Crown Castle
200 Spectrum Center Drive
Suite 1700
Irvine, CA 92618

RE: WCF21-036, 8215 SE 78th St, Mercer Island

I am providing the additional materials requested in response to your compliance review letter dated January 4, 2022, for the following referenced Application. Below I will note each item listed on the review as missing or incomplete and provide a response to satisfy each item of record.

NOTE: ALL BLUE COLORED EQUIPMENT IS NEW  
 NOTE: SEE DETAIL 2/D1.1 FOR POLE RISER PLAN

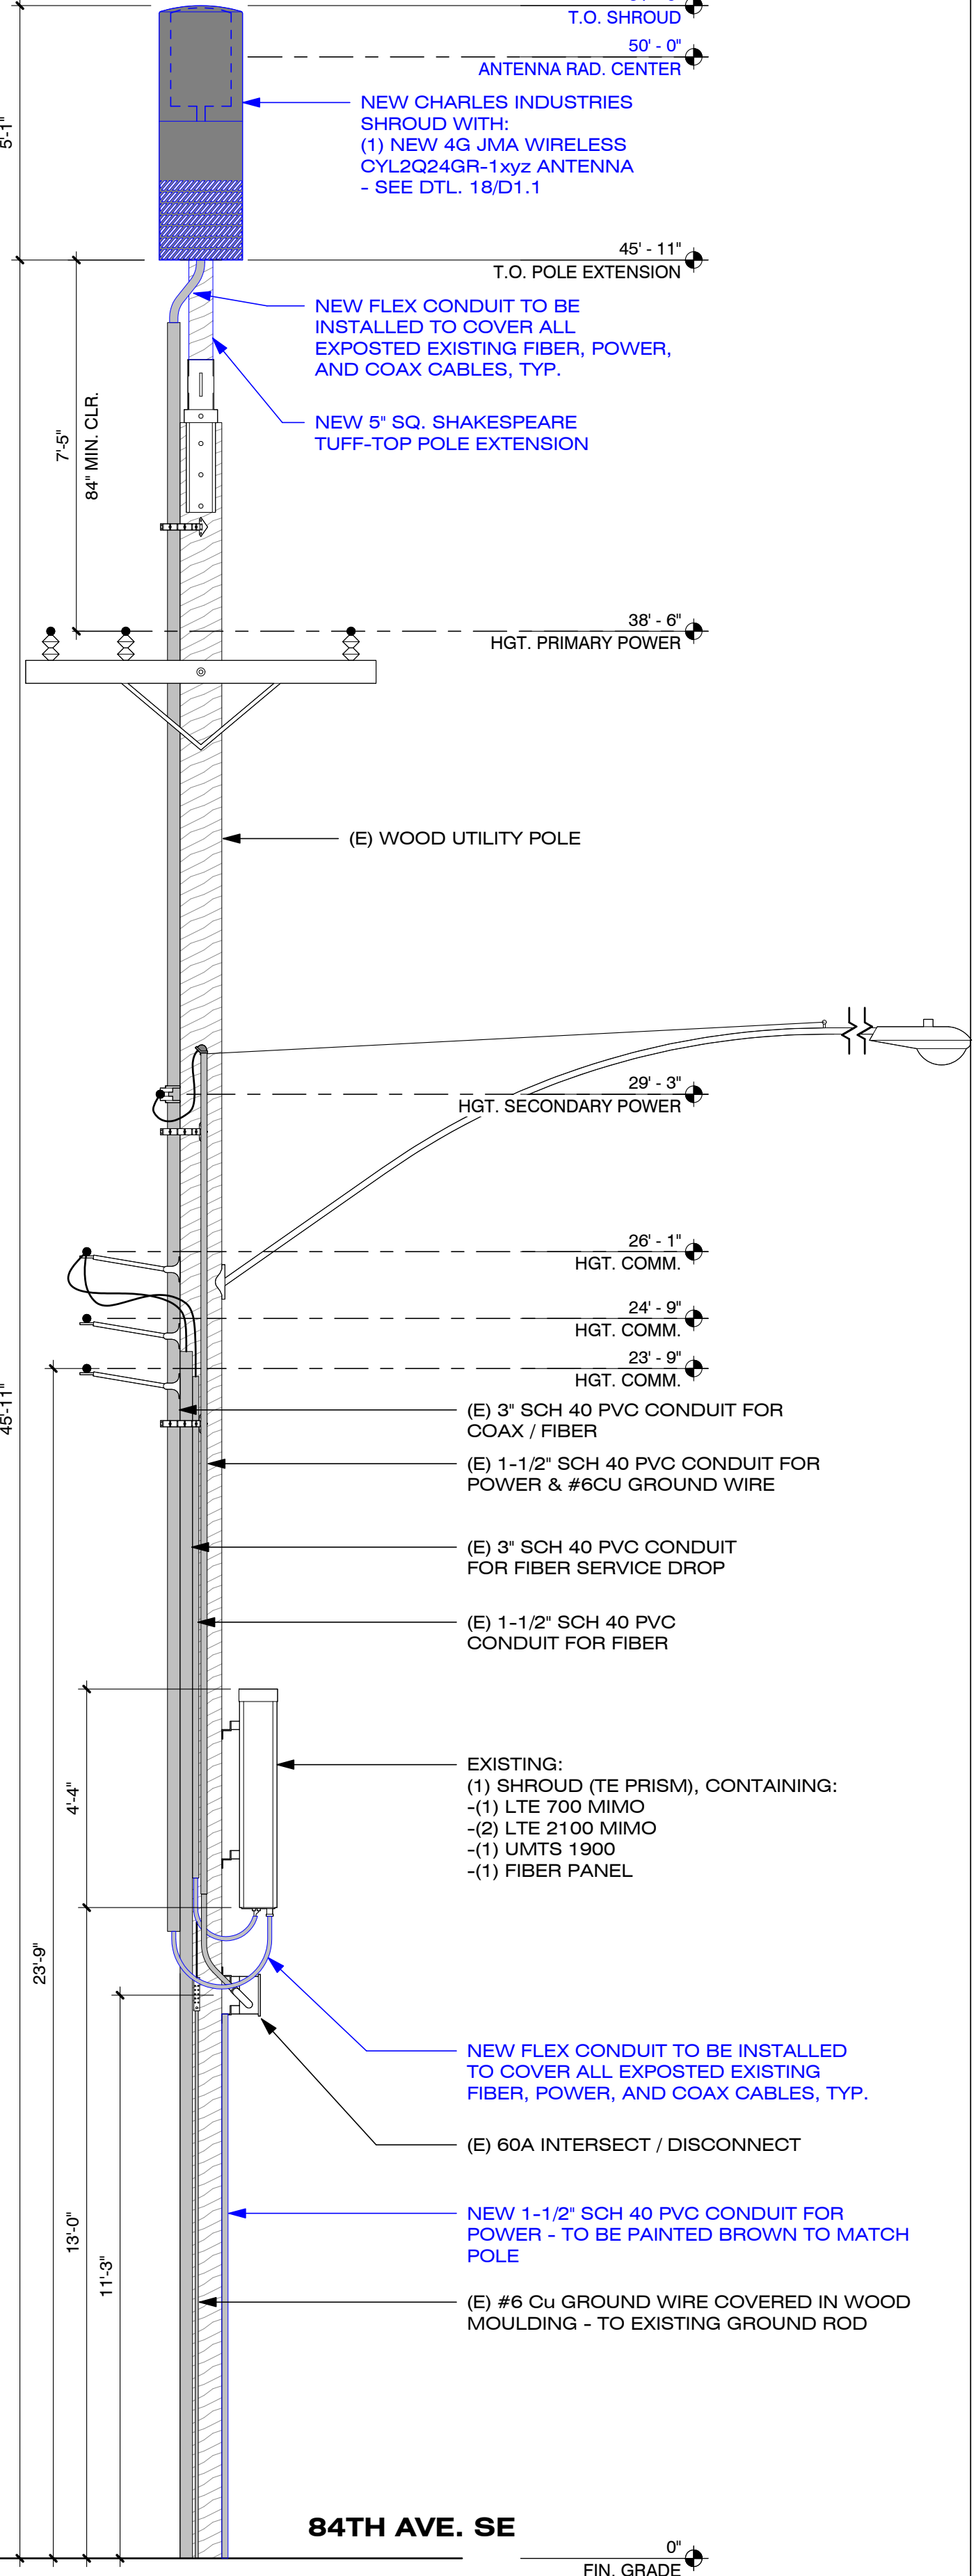
- 3. MICC 19.06.075(C)(13) requires all cables and wires to be routed through conduit along the outside of the pole. The provided plans show that the facility's wires are proposed to be exposed between the top of the main conduit and the antennas and between the bottom of the main conduit and the equipment cabinets. In the new application for a modification to an existing small cell facility, please revise the plans to show that all cables and wires will be contained within conduit from the antennas to the equipment cabinets.**

Crown Response: Please see revised construction drawings (A1.2, D1.1).
